Planning Officer: Mr S Davis

Planning Application Ref: BE/137/19/RES

Location: The Cottage, Shripney Road, Bognor Regis, PO22 9PA

Description of works: Application for approval of phase 2 reserved matters following outline permission BE/63/17/OUT (as amended by BE/131/18/PL) for 20no. dwellings

6.04 Plot 11 and 16

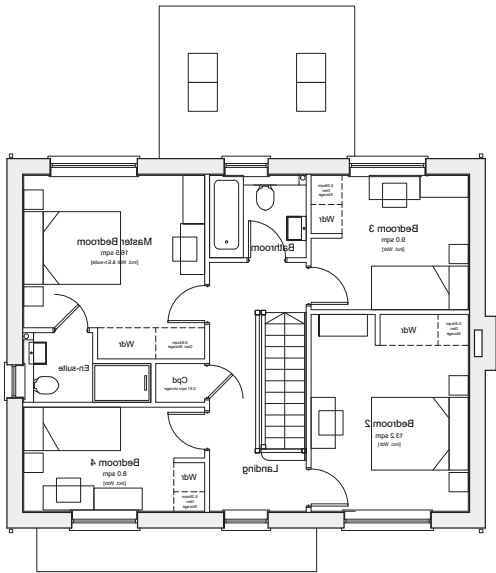
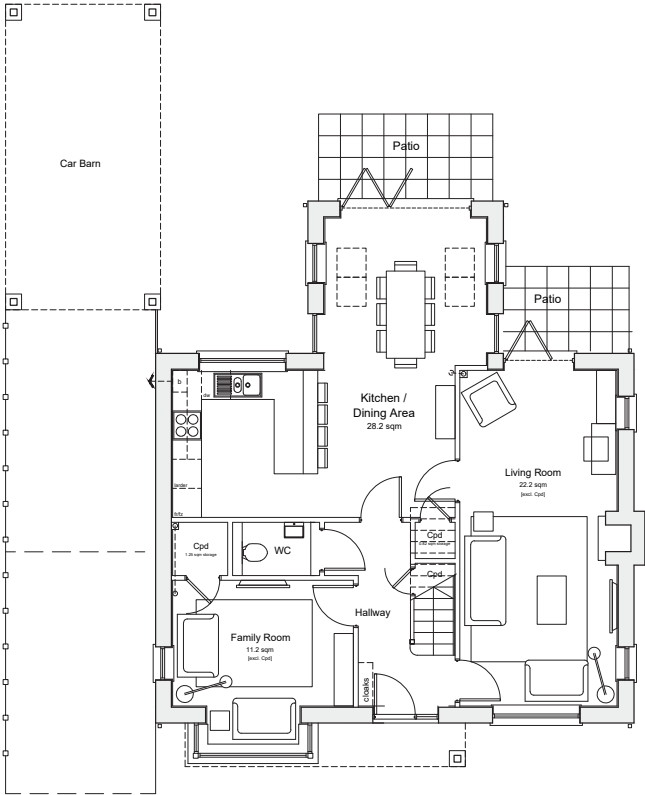
- It is apparent from the latest Proposed Site Plan (dwg.no. PL-003, Rev 4) that greater root protection area (RPA) incursion will occur at plots 01-06, 11 and 16. I find this unacceptable, especially given the progress which had been made to secure our arboriculturist's approval at Outline stage and as there is ample opportunity (no over-riding justification otherwise) to avoid RPAs. In respect of plot 16 again, T33 (TPO sycamore) will undoubtedly come under greater and hard-to-resist 'future residential pressure to prune', thus diminishing its position in the landscape.

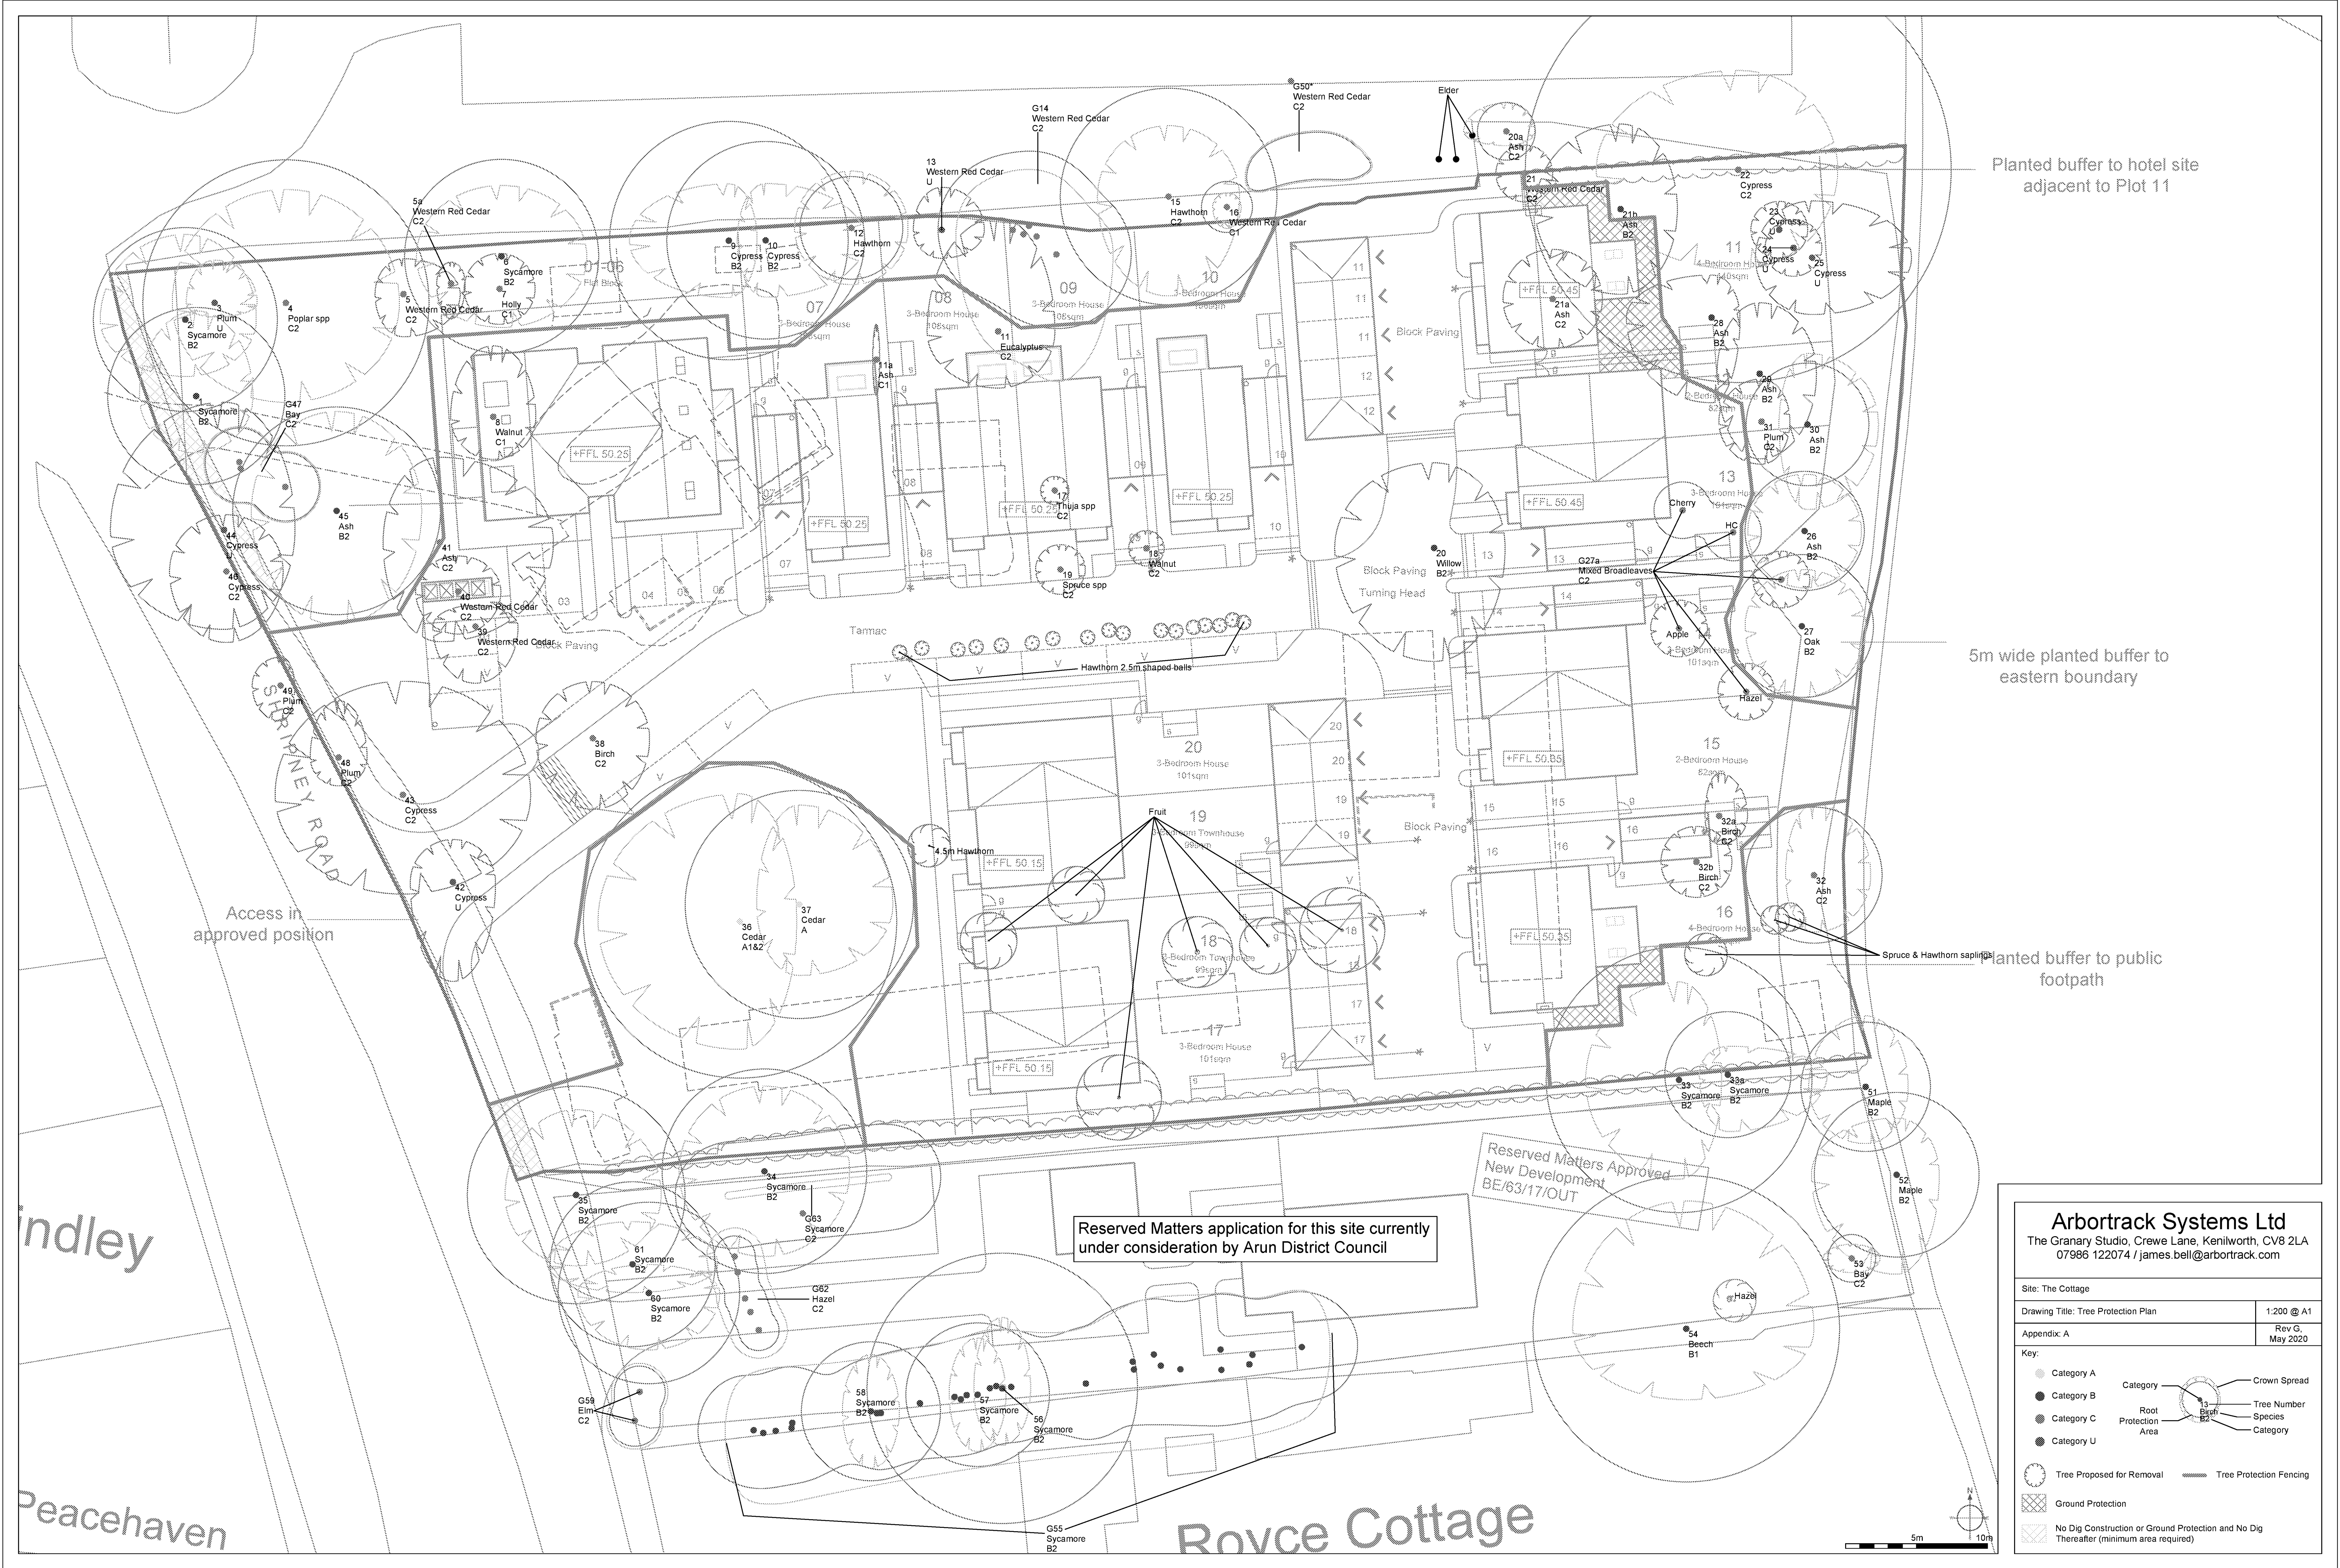
- The outstanding concern in respect of the footway link across the front of the site, which cuts through the RPA of T35 (TPO sycamore), appears not to have been addressed entirely. We should seek clarity on their intentions here; whether they intend to: i) implement a 'No-dig' engineering solution if levels permit, ii) extend the interior footway south across the front of plots 17-20 to link up with the east-west public footpath as previously suggested or preferably, iii) to terminate at the edge of the RPA.

- Foul water drains are proposed within the RPA of retained trees; to the rear of plots 01-06 and alongside plot 16, which I assume would involve damaging excavation work. Those trees to be affected are of significant screening value and/or a public amenity. This must be avoided and so the Foul Drainage Network needs revising at those locations.
